CITY OF ALBUQUERQUE

December 20, 2024

Re: Gibson In-N-Out
Traffic Impact Study (L15D047)
DRAFT October 2024
Via email jkruse@lee-eng.com

TRAFFIC CIRCULATION PLAN
 1 OF 2

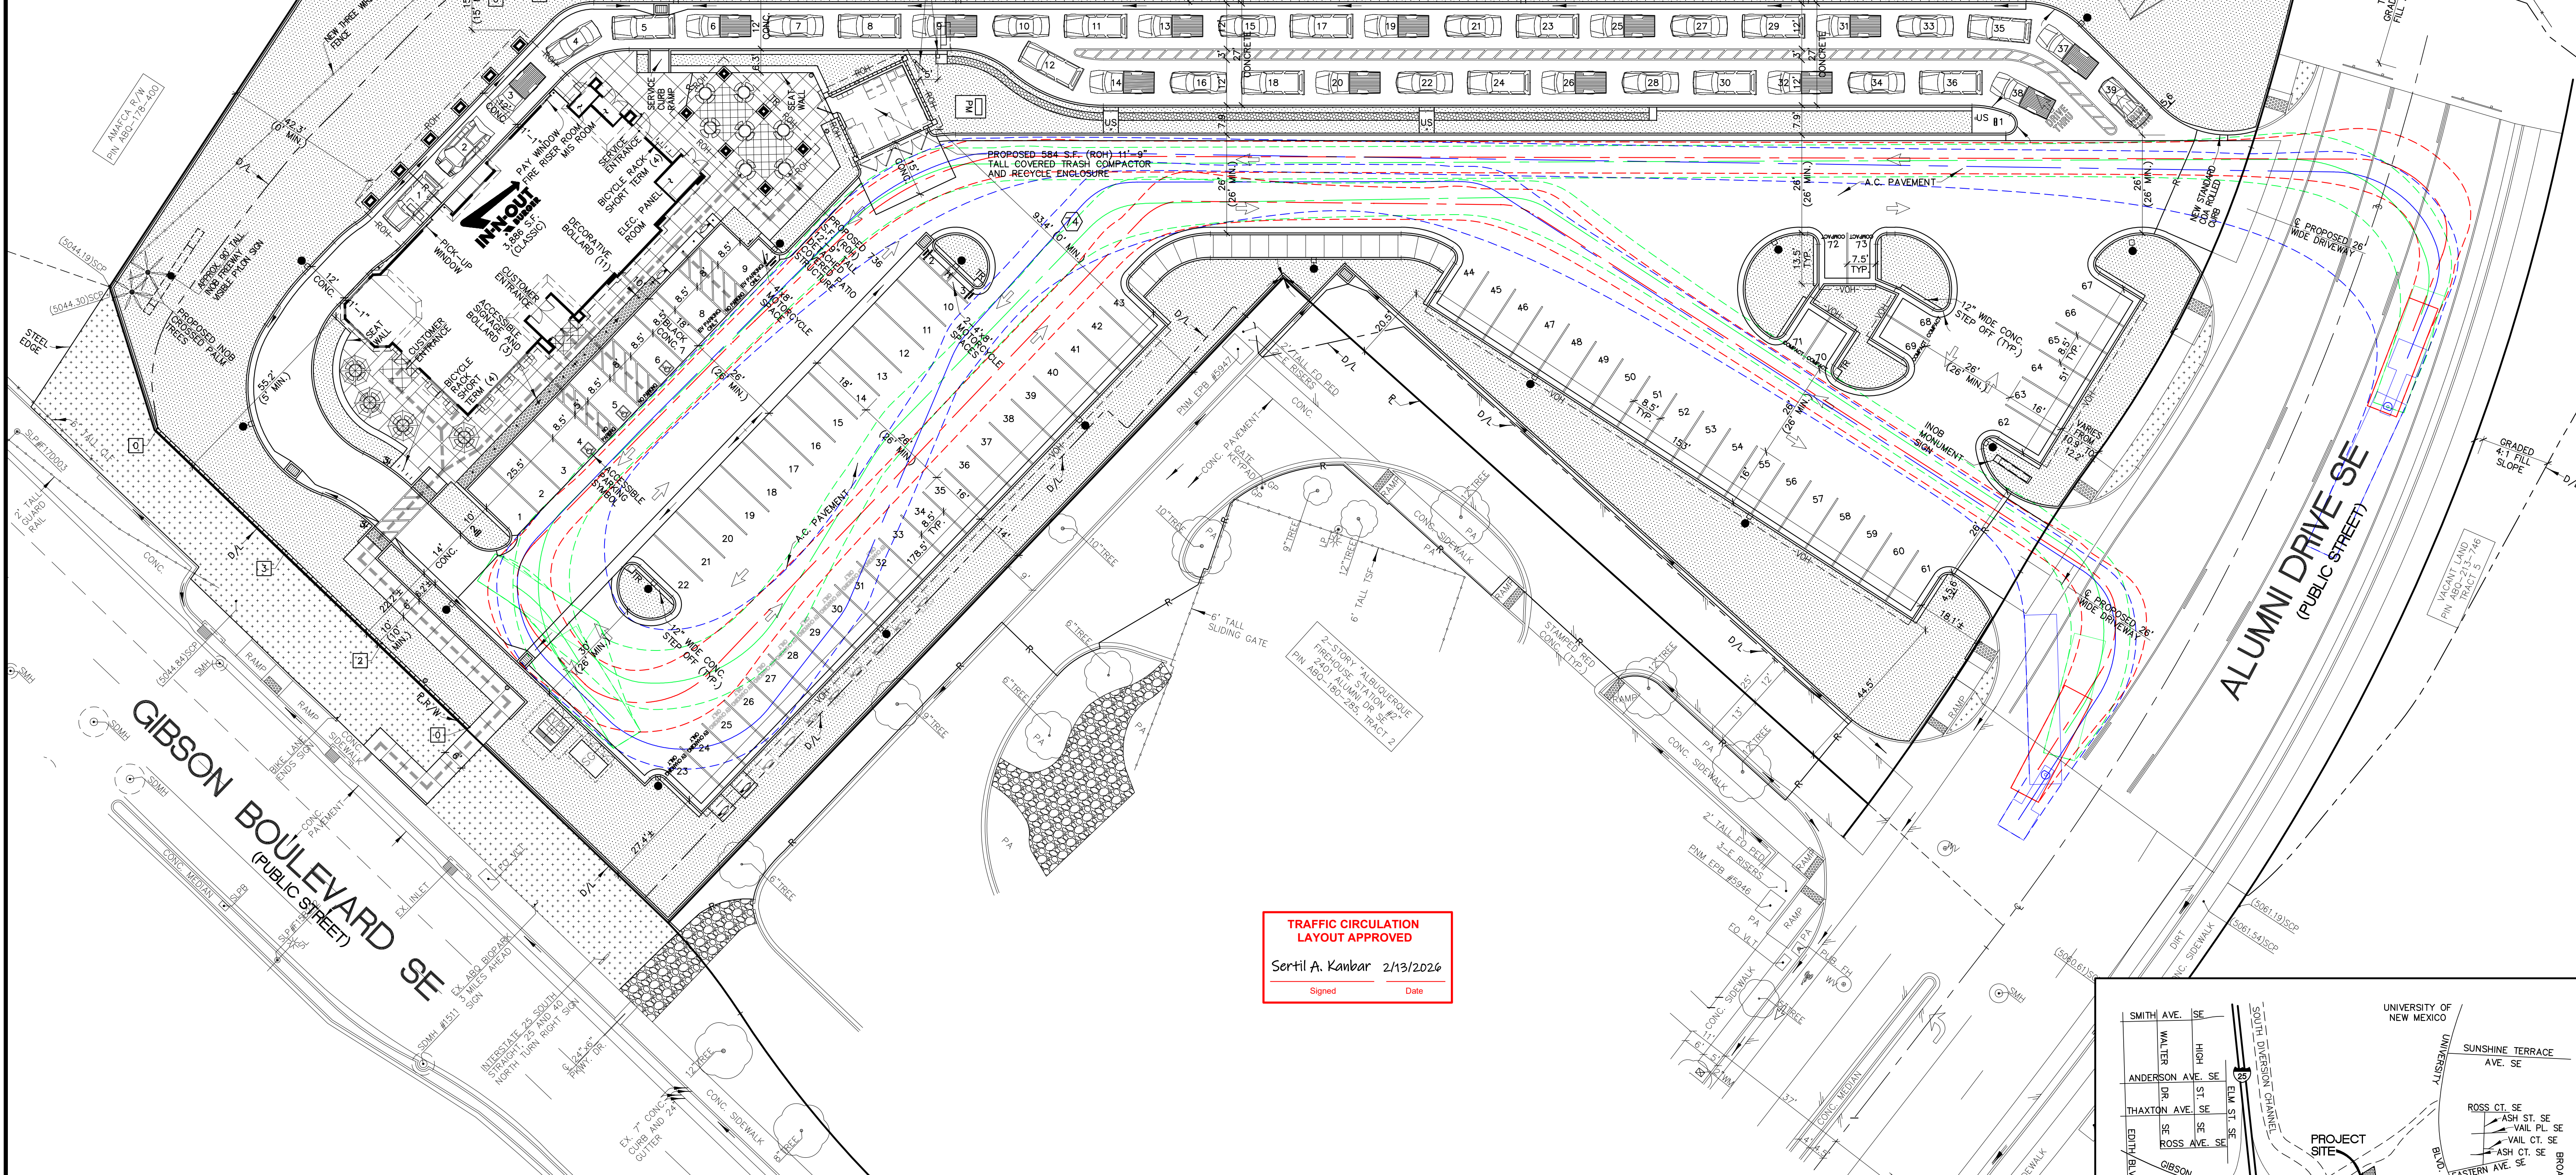
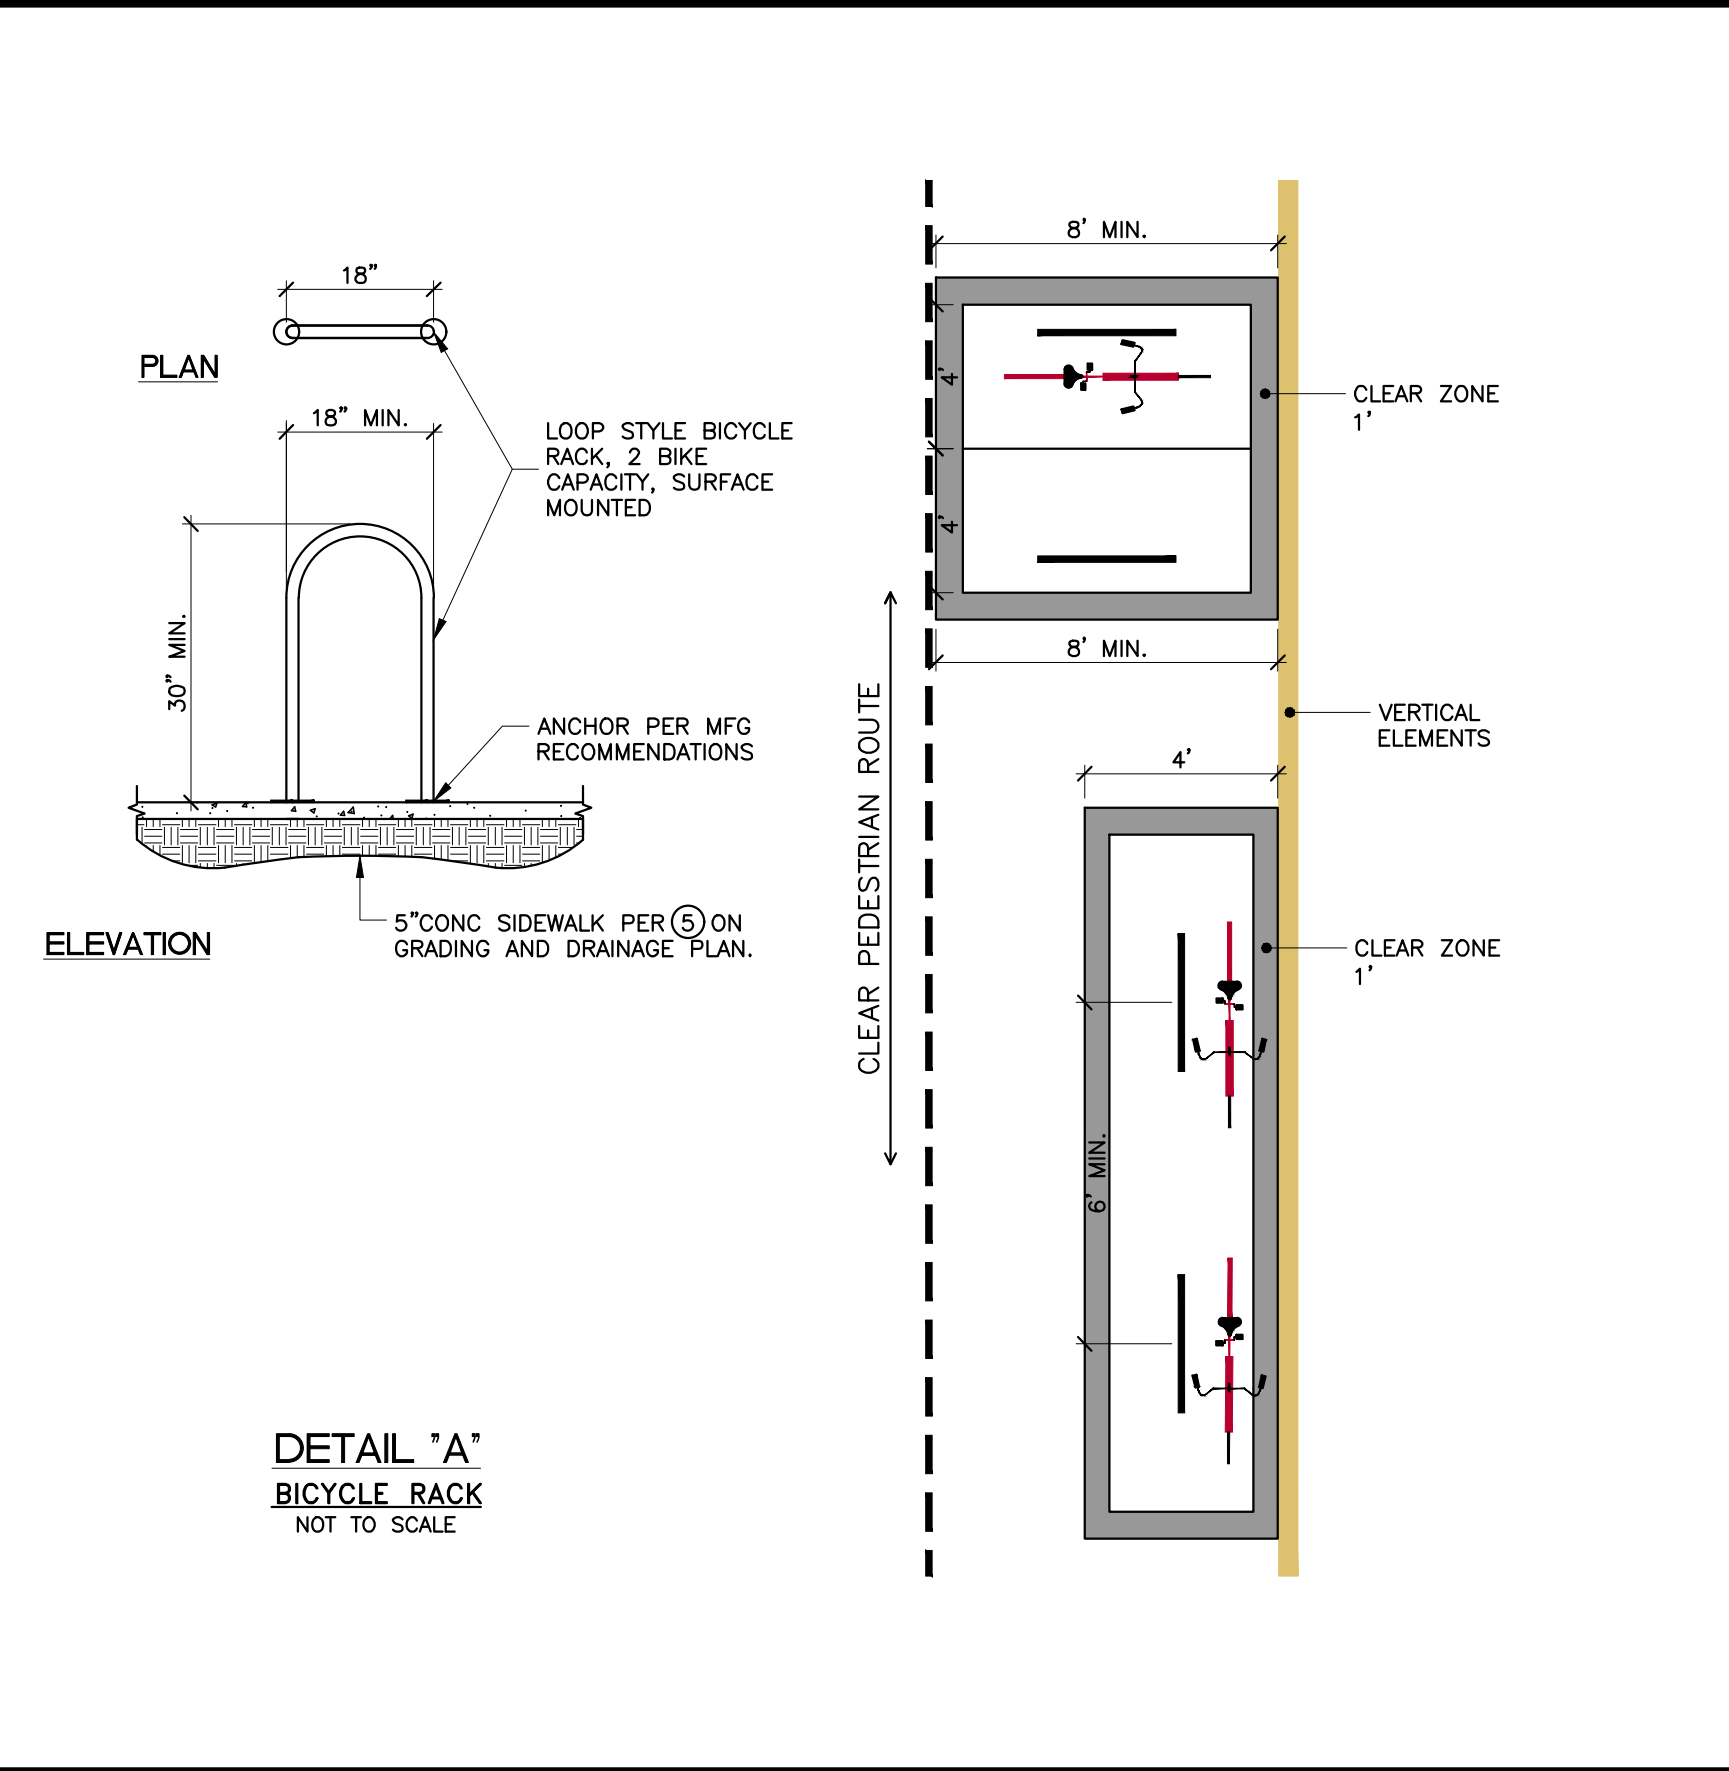
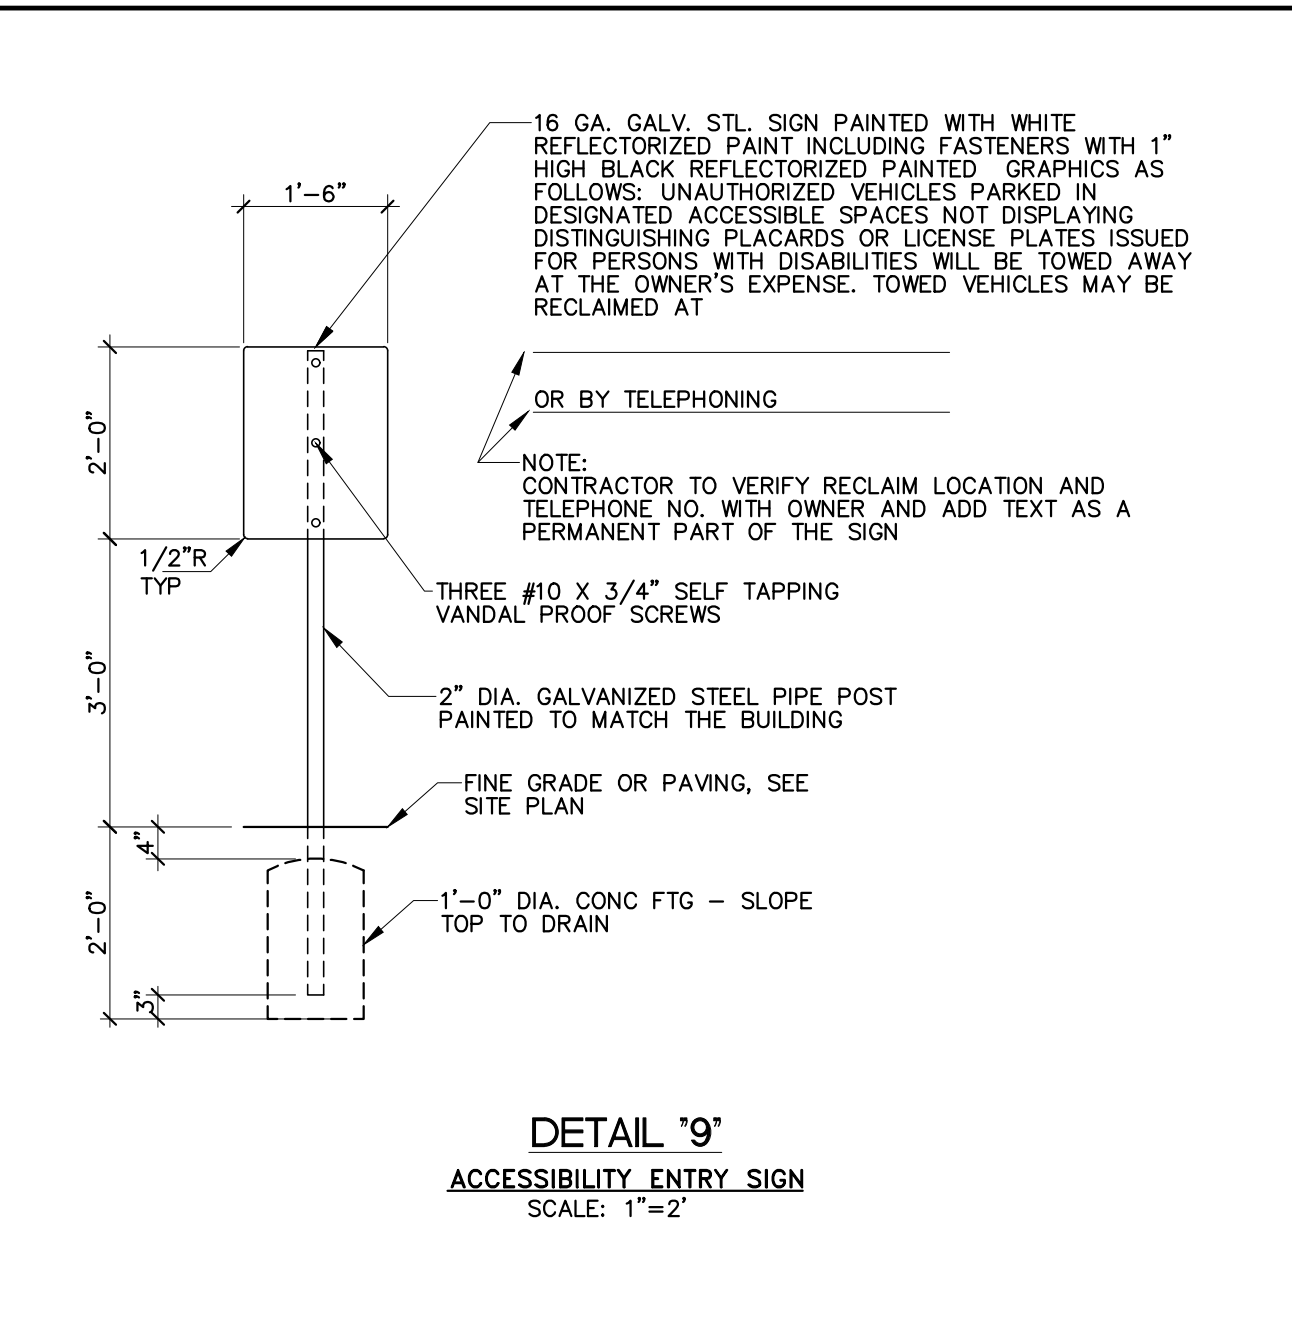
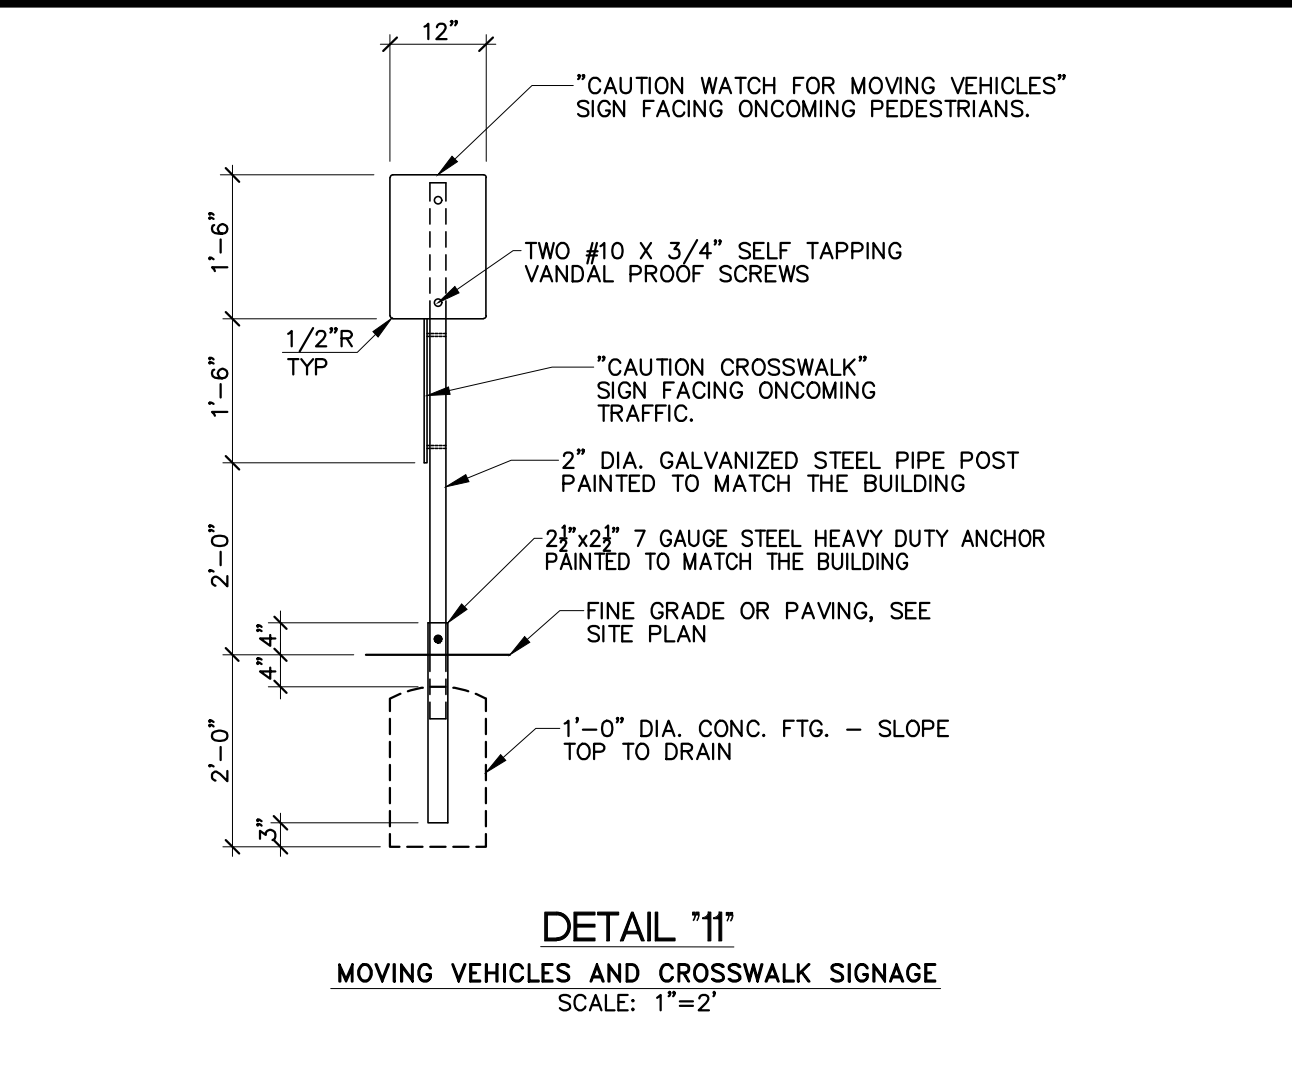
1. Trips were assigned to a driveway three, which does not exist. See HCS Two-Way Stop-Control Report pp 130 and 131, 158 and 159 of 173. Reassign trips to the two driveways shown on the Site Plan. Additional comments/questions may arise after the revised information is presented.

3. The Site Access and Justification paragraph mentions three access driveways, whereas, the Site Plan shows 2.
4. Provide the methodology/calculations used to determine the 160 ft turn lane length: decel, storage and taper or 95% percentile queue length.

5. Provide a clear 11" x 17" site plan that shows the dimensions and striping discussed in the Auxiliary Lane Analysis section.
